From: Nolan, Chris <Chris.Nolan@lancashire.gov.uk>
Sent: 22 September 2017 10:49
To: Stephen Kilmartin; planning
Cc: LHS Customer Service
Subject: D3.2017.0856 - land adj to The Beeches, 65 Whalley Rd, Langho

Planning Application No: 3/2017/0856
Grid Ref: 370340 434047

Proposal: Application for outline planning permission for the demolition of an existing garage and the erection of two detached dwellings including details of layout and access with all other matters reserved.

Location: Land adjacent to The Beeches 65 Whalley Road Langho BB6 8EF

Illustrative Layout and Streetscape

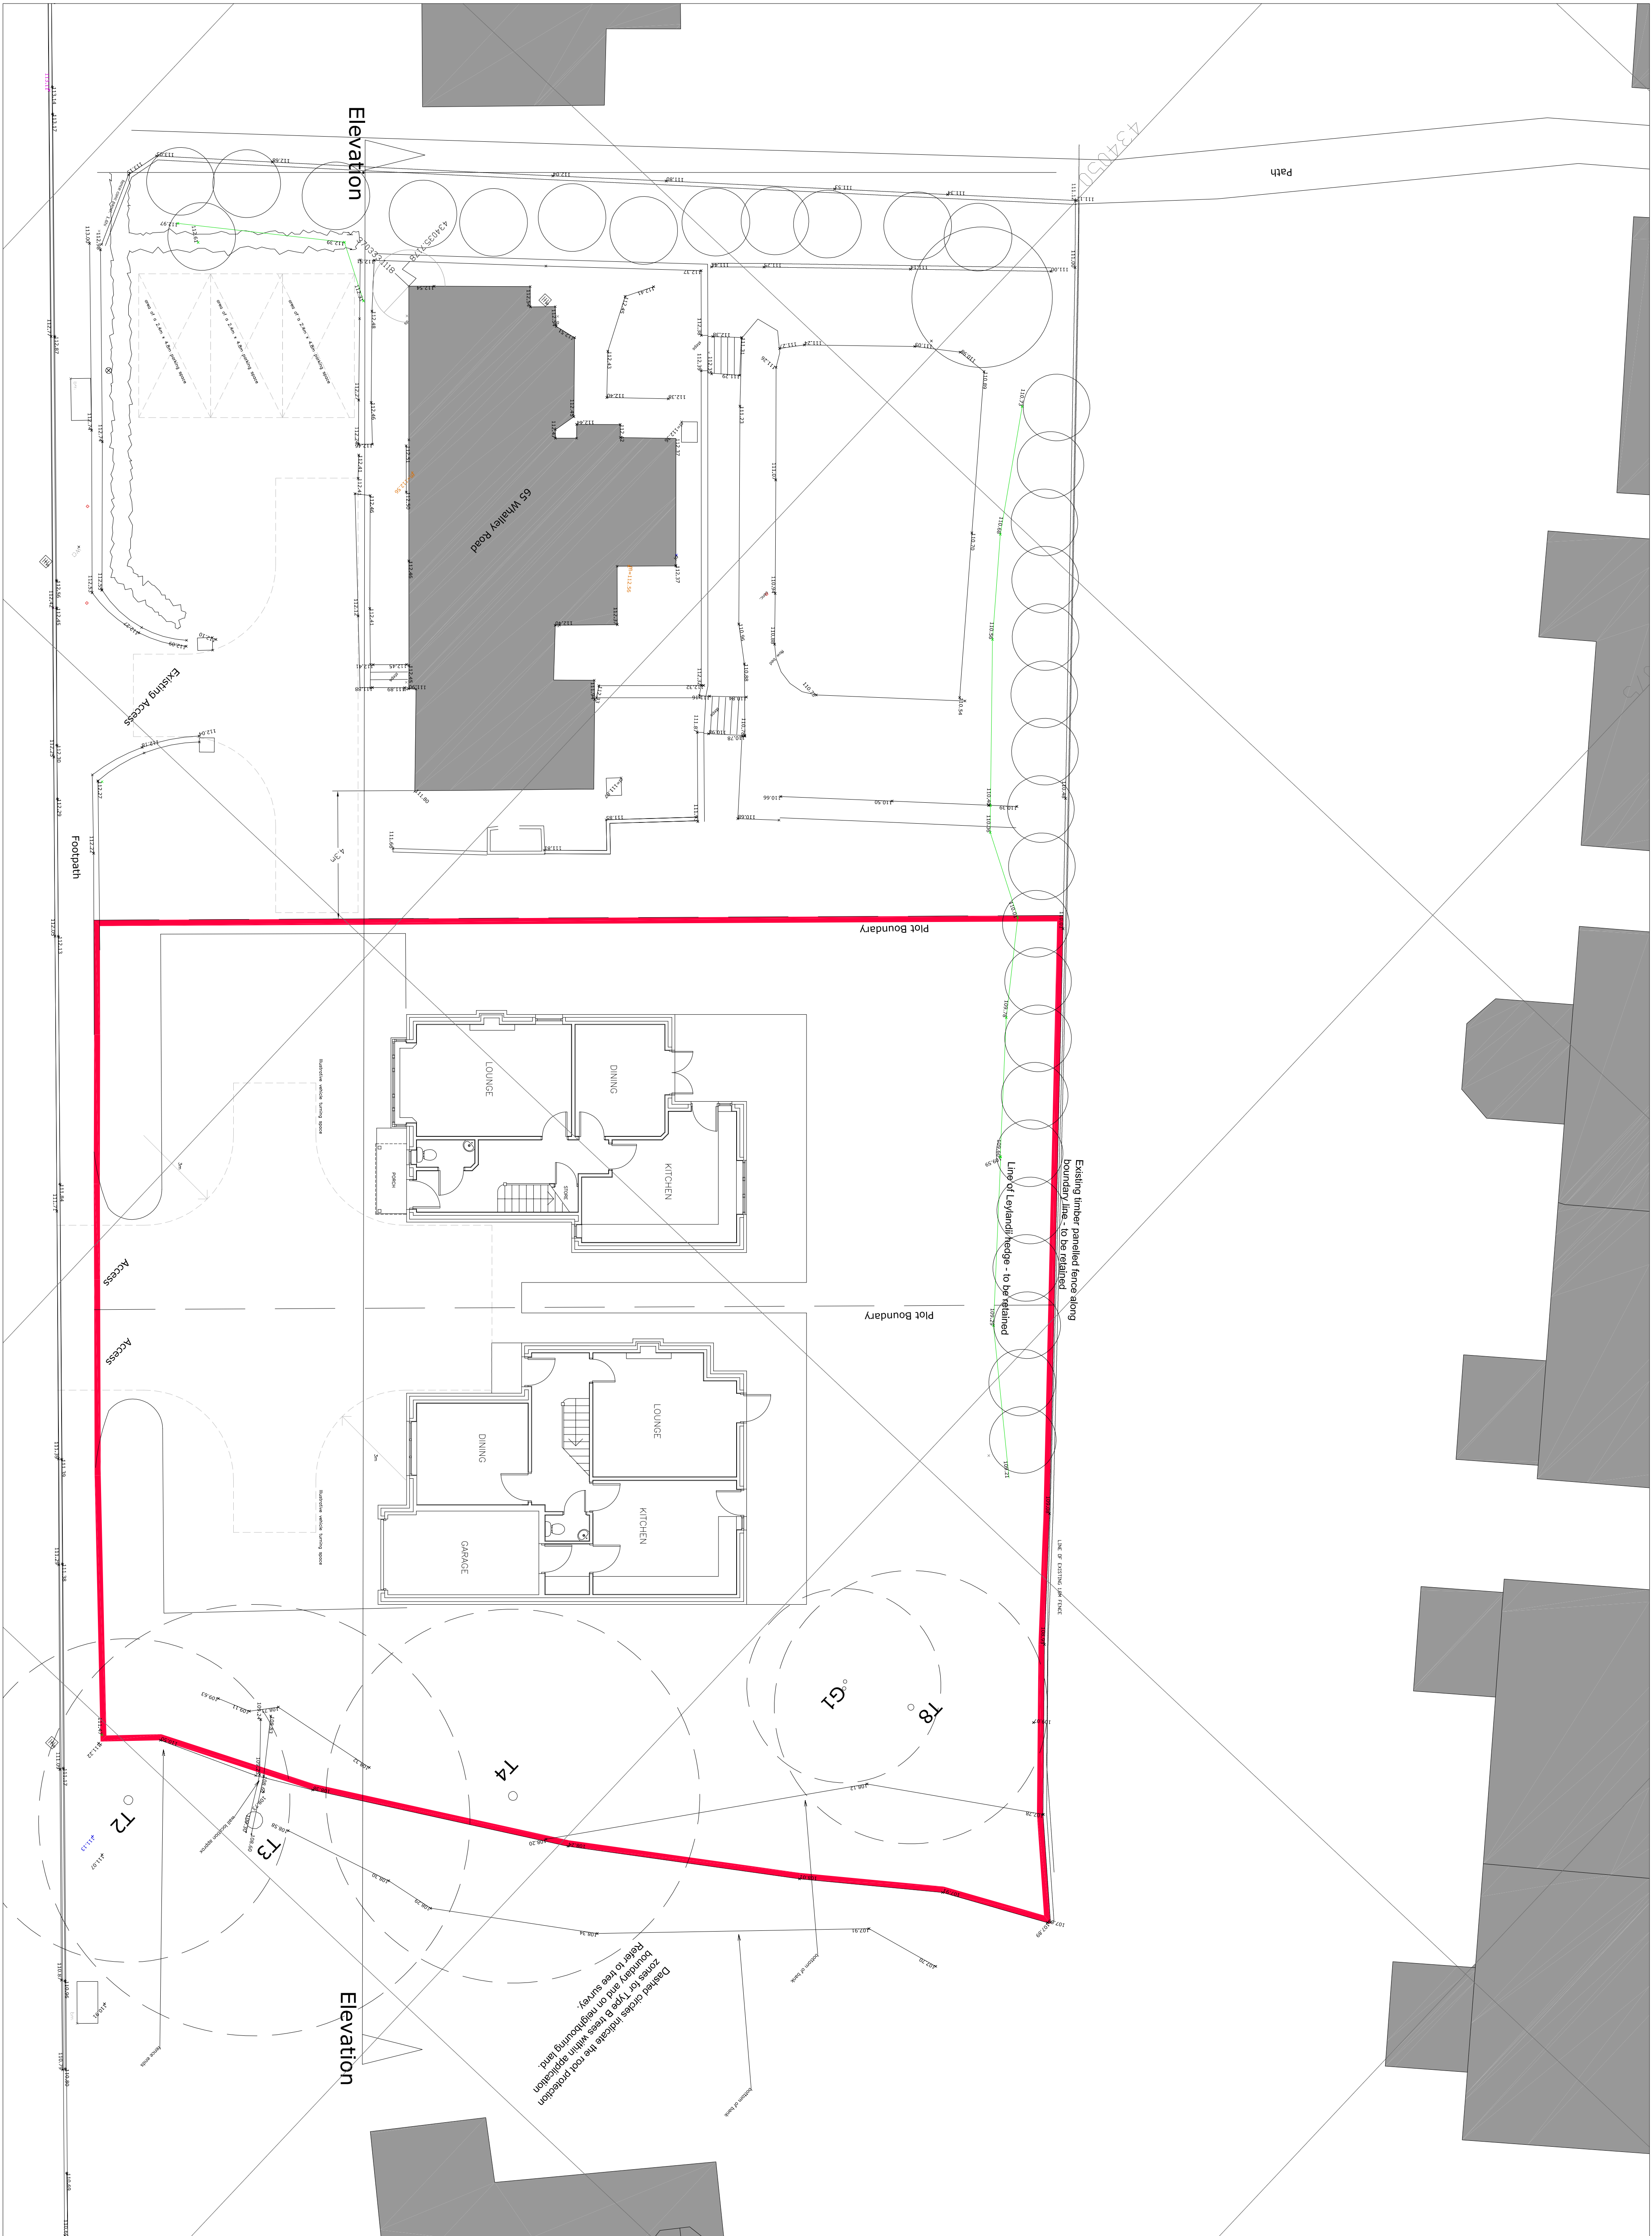
The plans indicate the retention of the present dwelling (The Beeches) and the erection of two further dwellings. The submitted plans do not indicate the number of bedrooms within the existing dwelling but the plans offer three parking places that will be sufficient for four or more bedrooms so the alterations to the layout with regard to this building would be acceptable as long as standard conditions are added with regard to gates. I would also be looking for provision for vehicles to be able to enter and leave using forward gears.

The plans for the two new proposed dwellings presently indicate that these will be four bedroom properties. Present parking standards would require each property to have sufficient parking for three vehicles along with the provision for access and egress using forward gears. If any garage space is to be included in this calculation then individual spaces will need to have minimum internal dimensions of 3m wide and 6m long.

The site inspection has indicated that, at present, the hedges in front of the Beeches and the arear to be developed both have a great deal of vegetation with high hedges. As alterations will be made to the present access to The Beeches as well as the access to the development site then the need for practical sightlines will also need to be addressed. This will involve the need to control the height of any vegetation that would be deemed to obstruct the necessary sightlines.

Looking at the latest information with regard to development of private cars I would now be looking that the new dwellings are provided facilities to charge at least one vehicle at each property.

1. Before the development hereby permitted becomes operative, the existing vegetation including hedges on the highway frontage of both The Beeches and the Development the sites to A666 Whalley Road shall be reduced to and be permanently maintained henceforth at a height not greater than 1m above the crown level of the carriageway of A666 Whalley Road. Reason: To ensure adequate visibility for the drivers of vehicles entering and leaving the sites.

2. The curtilage of each completed property along with the revised curtilage of the property known as The Beeches will have provision to park sufficient vehicles as required by the local parking standards. Reason that the properties would not have to rely on on street parking at the detriment of road safety.

3. The layout of the development and the remaining property known as The Beeches shall include provisions to enable vehicles to enter and leave the highway in forward gear and such provisions shall be laid out in accordance with the approved plan and the vehicular turning space shall be laid out and be available for use before the development is brought into use and maintained thereafter. Reason: Vehicles reversing to and from the highway are a hazard to other road users.
